Site Location/Project: 90-102 Regent Street, Redfern, NSW

Our Ref: 210215_90-102 Regent St_Ad

Addendum to Arboricultural Impact Assessment Report (AIA) dated 29 September 2020

GROUND LEVEL | PUBLIC DOMAIN LANDSCAPE PLAN

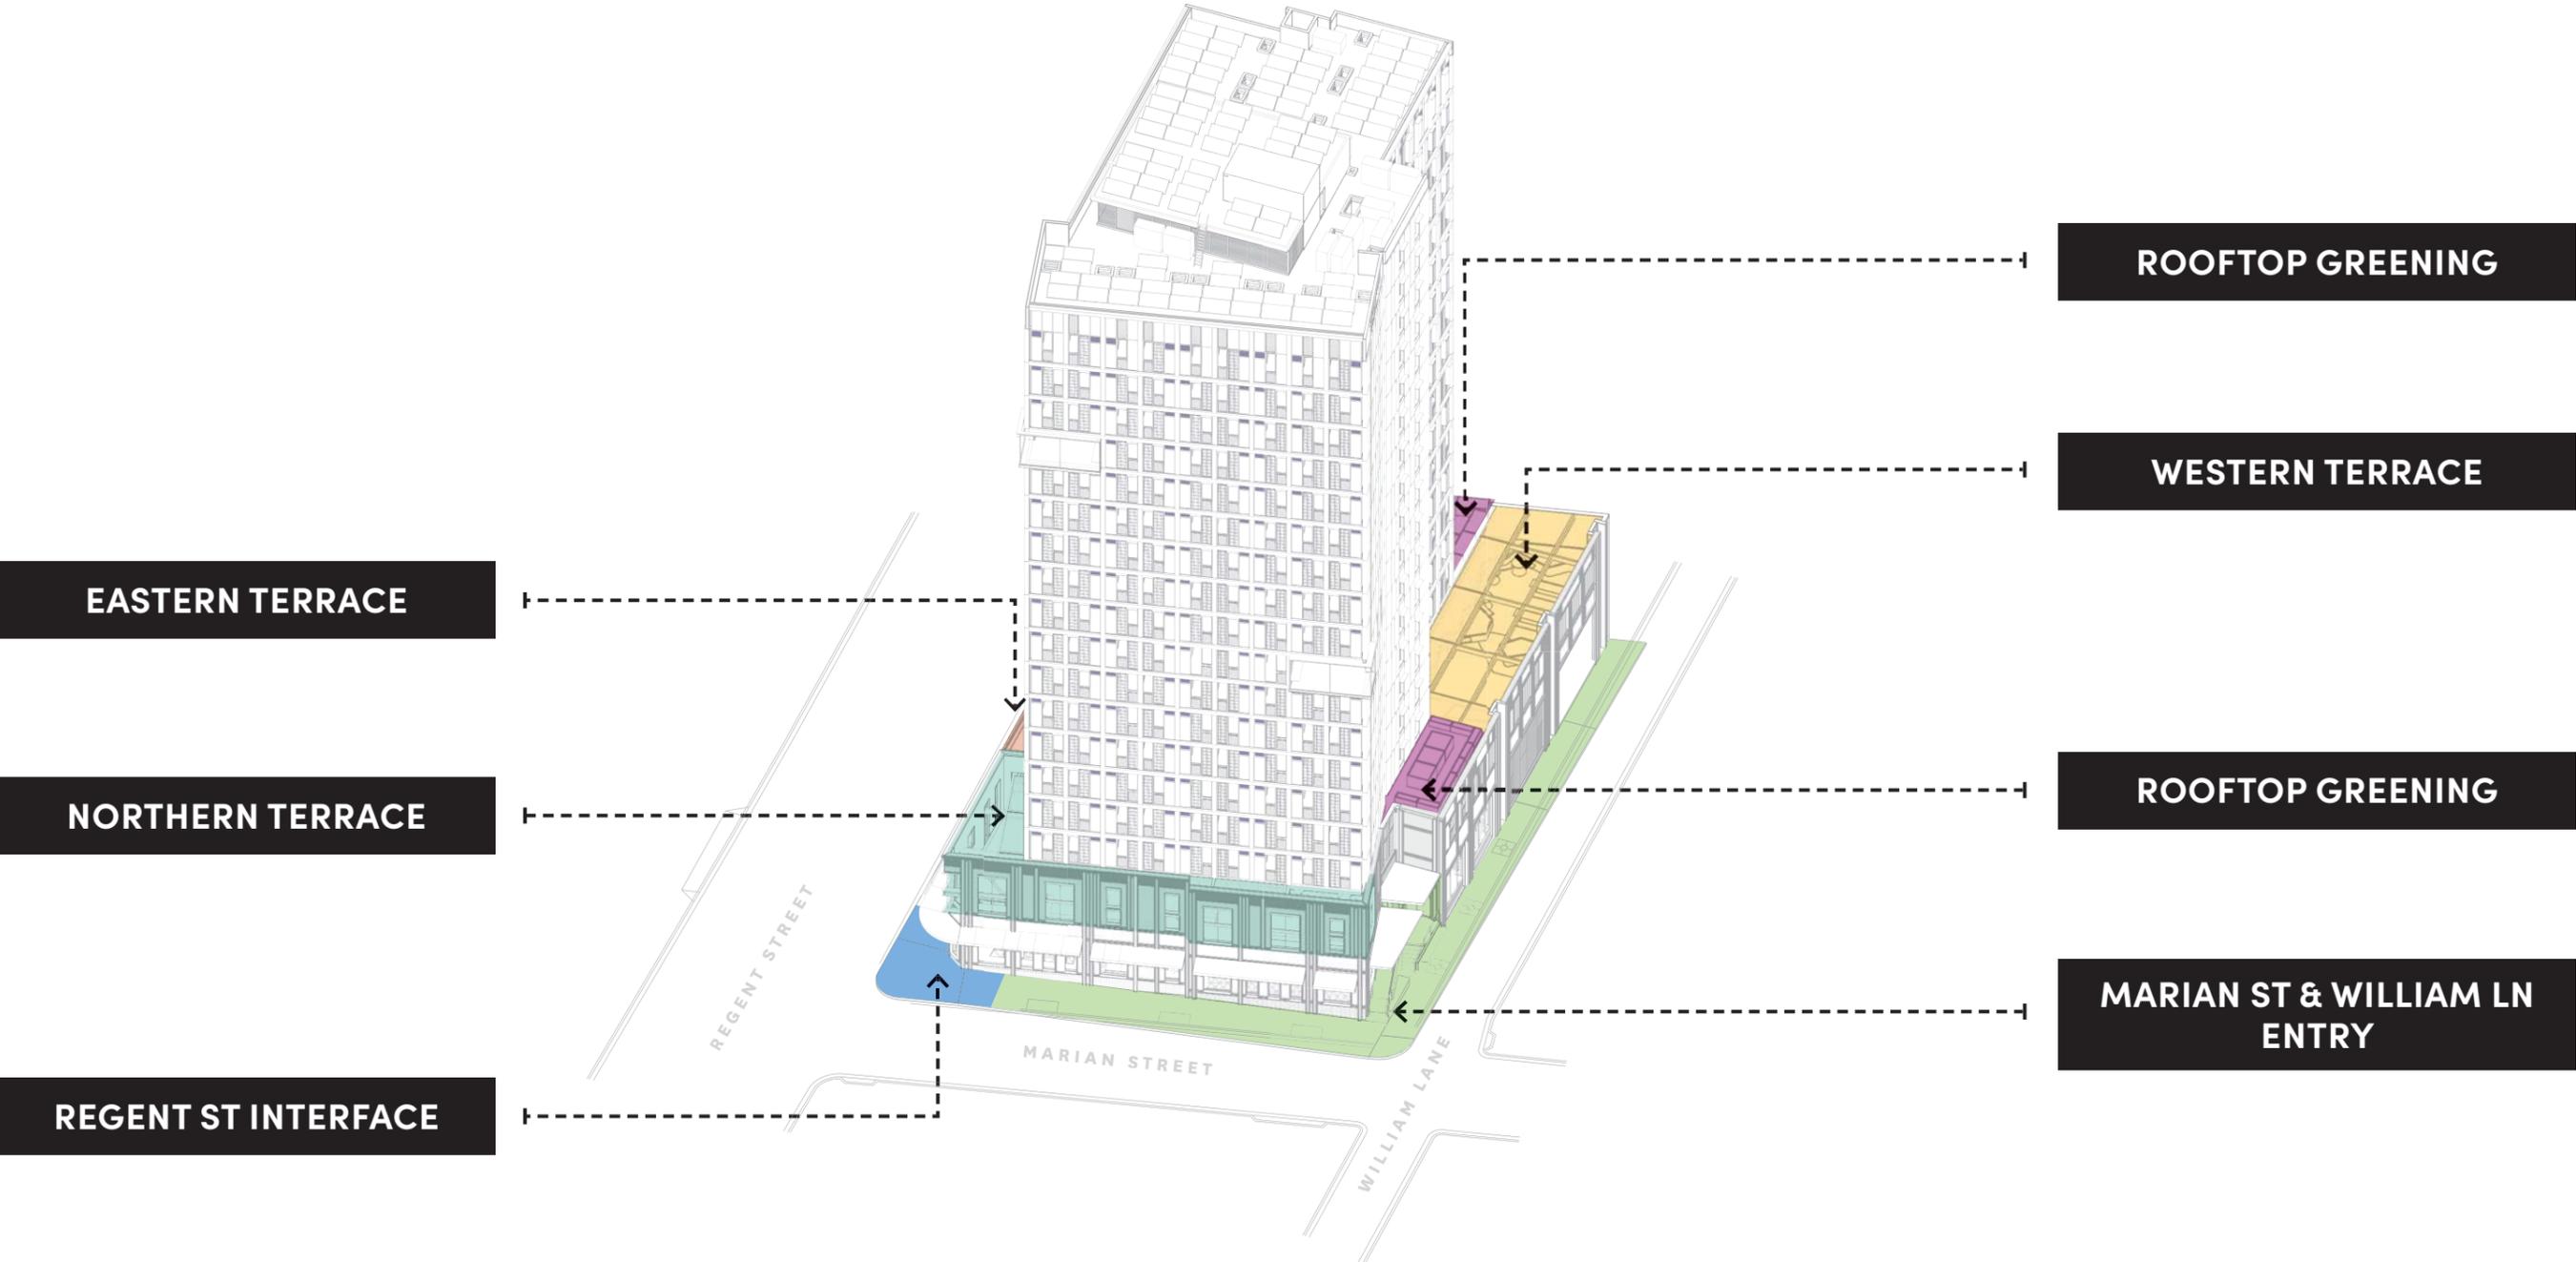
Tree 1 is the only existing street tree at Regent Street adjacent to this awning, which is a Plane Tree (*Platanus x acerifolia*) that is semi mature in age class. Three new street trees are also proposed adjacent to the Regent Street awning. Canopy pruning for tree 1 will be required to accommodate the awning, the pruning will be required as per the specifications in section 9.2 of the AIA report. The pruning will not adversely impact the condition or amenity value of the tree and is therefore considered minor and acceptable.

The public domain works at Regent Street, in the Tree Protection Zone (TPZ) of tree 1, include the removal of the existing surface and replacement with concrete unit paving. The public domain works at Miriam Street, in the TPZ of tree 2 and 3, include the removal of the existing surface and replacement with in-situ concrete paving. To minimise the impact to tree 1, 2, and 3, the construction of the new concrete paving on both streets must be carried out in accordance with Part D - Technical Guidelines of the City of Sydney Street Tree Masterplan 2011. All demolition and construction works must be carried out in accordance with AS4970 Protection of trees on development sites (2009), see section 11 of the AIA report for more information. Providing that the public domain upgrade works are carried out in accordance with these specifications, the trees will not be impacted development works.

The awning height has been lowered to between 3.2m-4.2m to allow for the slope of Regent Street. The awning depth along Regent Street has been reduced from 2.8m to 2m.

All three of the new trees at Regent Street can be formatively pruned in accordance with AS4373 Pruning of amenity trees (2007) to crown lift/modify the shape of the crown to remove/reduce lower branches below a height 3.2-4.2m (the height of the awning) to prevent branches conflicting with the awning in the future.
